# CITY OF ALBUQUERQUE

**Re: US Electrical Corporation  
314 Arizona St. SE  
60-Day Temporary Certificate of Occupancy  
Transportation Development Final Inspection  
Engineer's Stamp dated 9-20-21 (K18-D092A)  
Certification dated 3-20-22**

Based upon the information provided in your submittal received 03-22-22, Transportation Development has no objection to a 60-day Temporary Certificate of Occupancy based. This letter serves as a "green tag" from Transportation Development for a 60-day Temporary Certificate of Occupancy to be issued by the Building and Safety Division.

SITE PLAN
A1.1 1" = 20'-0"

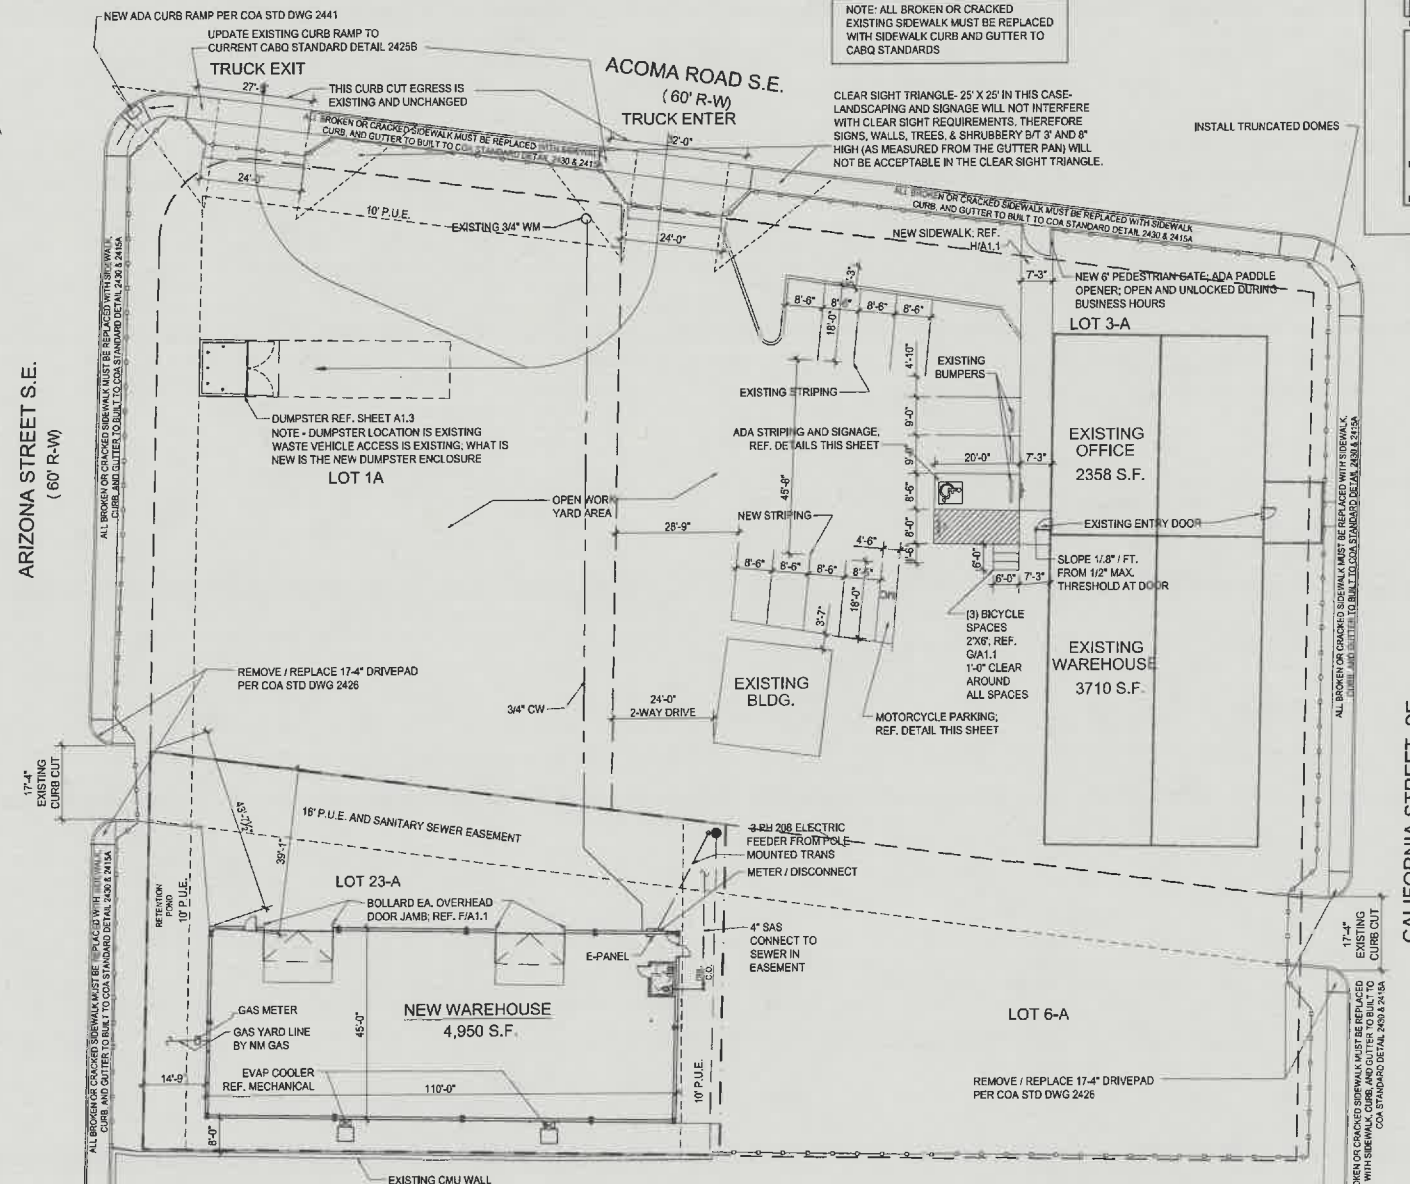
Arizona/ California drivepads:

- Drivepads Entrance were not built per Approved plan. COA std dwg 2426
- COA std dwg 2426: requires 6ft valley gutter and ADA access across drivepad entrance.
- The drivepads that were built are not ADA compliant.

Once these corrections are complete, email pictures & redlined TCL plan showing the changes to [PLNDRS@cabq.gov](mailto:PLNDRS@cabq.gov), email pictures to [malnajira@cabq.gov](mailto:malnajira@cabq.gov) for release of Final CO.
